**Consultant's Report to the Inspectorate Ecologist**  
**Prepared for An Bord Pleanála (ABP)**  
**Case Ref. No.: ABP-313586**  
**Date: November 2024**

<b>Development</b>	The development consists of the construction of an extension to an existing wastewater treatment plant (WWTP) where the works include:- A) Demolition of an existing storage building (17.50m <sup>2</sup> ) and construction of a new single-storey industrial type building to enclose the DAF unit granted planning permission under planning reference LB180300 and to provide new enclosed storage and control rooms (total floor area 119m <sup>2</sup> ). B) Install a new sludge press at intake to WWTP, change aeration tank to anoxic tank, install 2 no. additional aeration tanks, alteration to perimeter berm to increase the footprint of WWTP, by 539m <sup>2</sup> to that granted planning permission under planning permission LB180300. C) Treated wastewater rising main from the site of the proposed development to new discharge point at the River Boyne (distance 7.2km), where pipeline shall be laid along a section of Windmill Road, the L1013, Yellow Furze Road, the L1600 (Boyne Road), and the unnamed local road leading from

Figure 4.1: Assimilative Capacity Results for the River Boyne at 400 M³/day

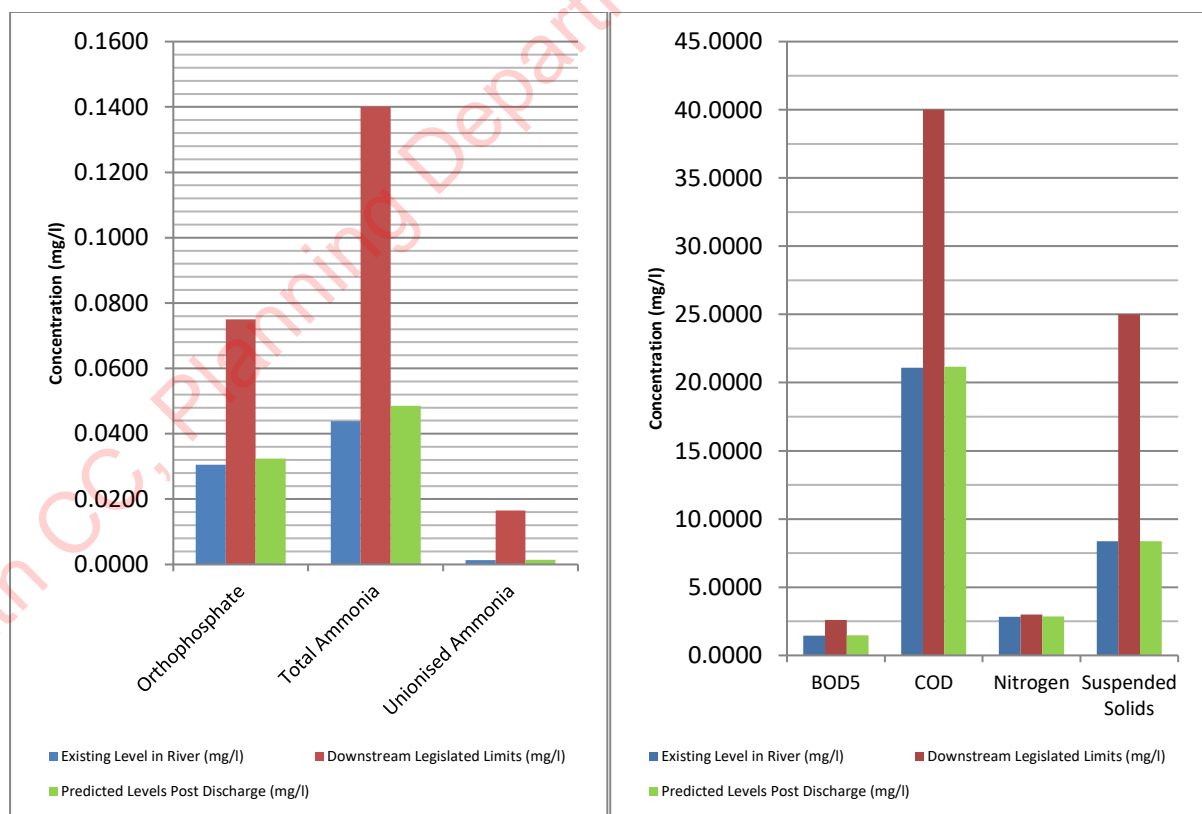
The results of the analysis confirmed that molybdate reactive phosphorus (0.08 mg/l), total ammonia (0.16 mg/l) and nitrogen (3.23 mg/l) levels were found to exceed the EQS thresholds in the vicinity of the outfall (EIAR, 2022, p. 113 & p. 226). It was stated that for each of these contaminants, after a short distance downstream of the discharge point (ranging from 3 - 6m), the pollutant(s) were sufficiently dispersed (EIAR, 2022, P. 226). However, it was later confirmed that the molybdate reactive phosphorus, total ammonia and nitrogen

concentrations exceeded the EQS thresholds for 8m, 7m and 20m, respectively, during estimated minimum-flow simulations (EIAR, 2022, attachment 8.5, section 4.5.2, p. 26).

Given that the proposed discharge flows may range up to 400m<sup>3</sup>/day, any Assimilative Capacity Assessment and/or modelling inadequacies (lacunae), and/or associated failure(s) to achieve downstream legislative limits, significantly increases the risk of potential detrimental effects on the receiving water quality and receptors. The rationale stated for excluding the Navan WwTP input from modelling analysis, based on the use of low-frequency historical EPA monitoring data results, that have been heavily averaged, *is not accepted*. Based on the latter and the reasons previously highlighted, the results of the current Mixing Zone Model Report are deemed to be *inconclusive*.
